From: Amanda Scholes on behalf of Planning.Responses
Sent: 07 December 2017 08:39
To: Planning Scanning
Subject: FW: Planning Consultation on WA/78/17/DOC

Surface Water Drainage (Condition no.4) Comments;

APPLICATION NO: WA/78/17/DOC

Site Address: The Red Cottage The Street Walberton BN18 0PQ

Project: Red Cottage, West Sussex
Drawing No.: 536/501
Drawing Title: Typical Soakaway Section A-A
By: JD
Date: November 17

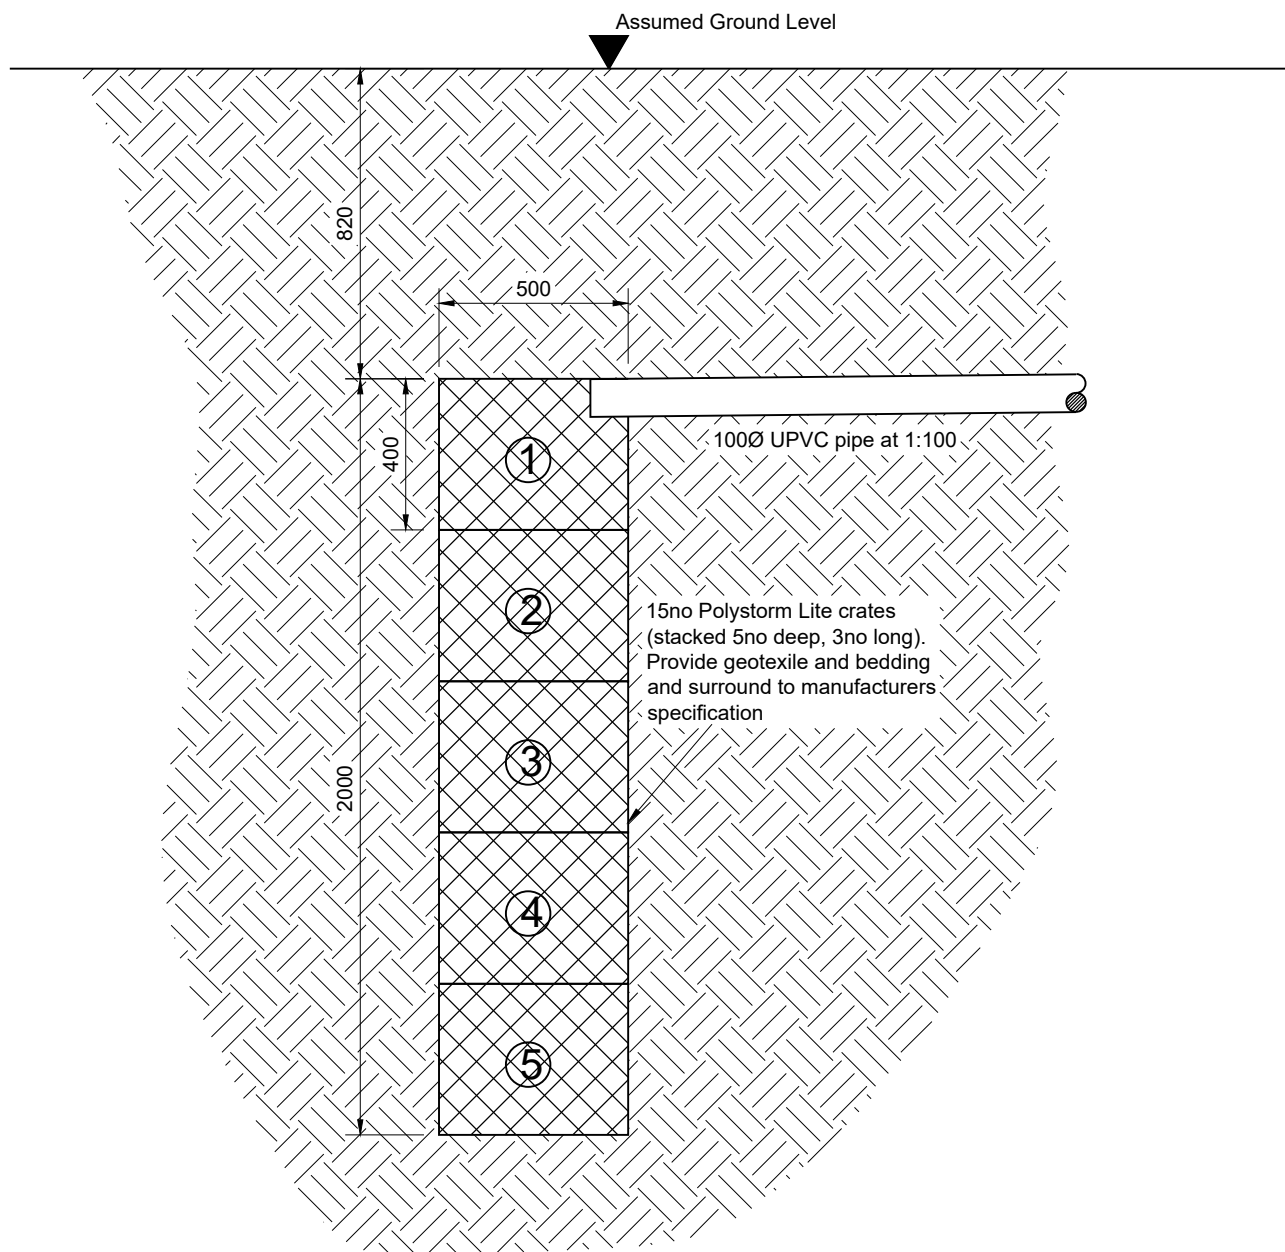
1. The applicant has not provided evidence of winter groundwater monitoring or winter percolation testing. All to be done at an agreed time during the winter. This is critical to the design.
2. Once item 1 has been established, further discussions can be had in terms of the design.
3. Ultimately, hydraulic calculations will be required to confirm that the 1 in 100 year storm event + climate change allowance can be stored on site.
4. Drainage arrangements for the driveway and any other impermeable areas need to be included.
5. The construction detail for the crated soakaway is likely going to require alteration, due to the likelihood of a relatively high water table. This will be confirmed by item 1.
6. Catchpit construction details will be required.
